# CITY OF ALBUQUERQUE

**Re: SW Corner of Sage & Unser TIS final, COA approval**  
Traffic Impact Study, HT#M10D023  
Report dated April 19, 2023  
Engineer's Stamp 4/19/2023  
Via email [tbrown@tierrawestllc.com](mailto:tbrown@tierrawestllc.com)

The subject Traffic Impact Study received on April 19, 2023, has been reviewed by the City of Albuquerque Planning Development Transportation Section. The City has approved the study and will require the following infrastructure improvements to be constructed by the developer. In addition, the MRGOG Roadway Access Control on Unser Blvd. for Driveway "B" will require revision and approval of the access modification prior to the construction of this development.

DRIVEWAY B & C EXHIBIT
1:30

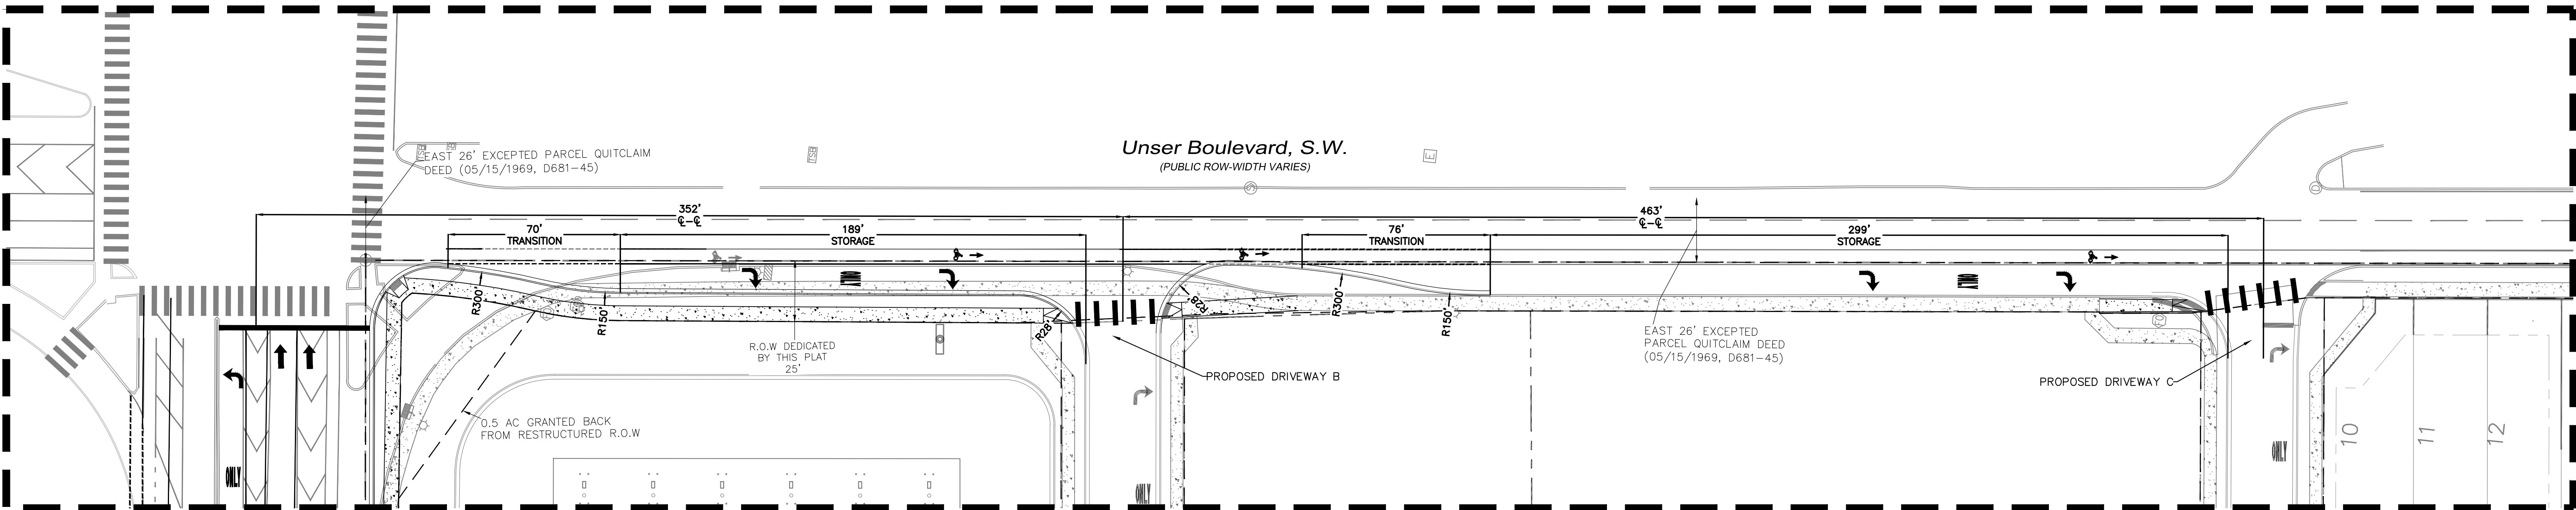
- Unser Blvd. / Driveway "B" – A SB right-turn deceleration lane is warranted for southbound right-in access into the proposed site. This storage length will consist of 240-ft in storage length.

DRIVEWAY A EXHIBIT
1:30

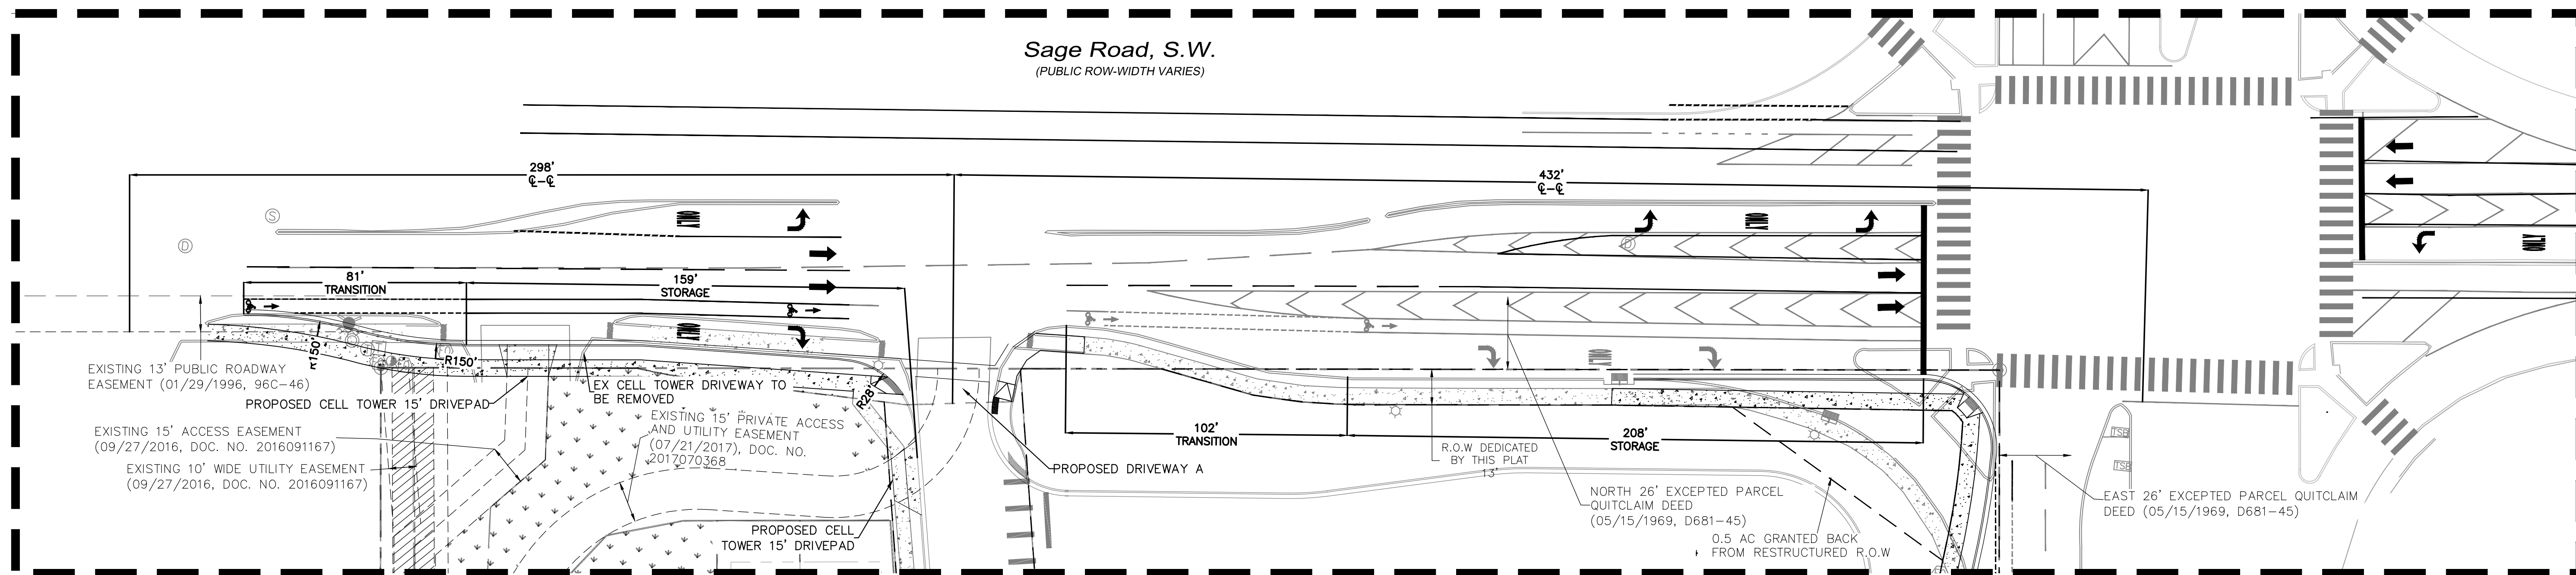
- Sage Rd. / Driveway "A" – Driveway "A" is an existing full access, unsignalized driveway north of the proposed site. This should still operate as a full access driveway and match the existing width of the access point. An additional right-turn deceleration lane is warranted for right-turn access into the proposed site development with a storage of 240-ft.
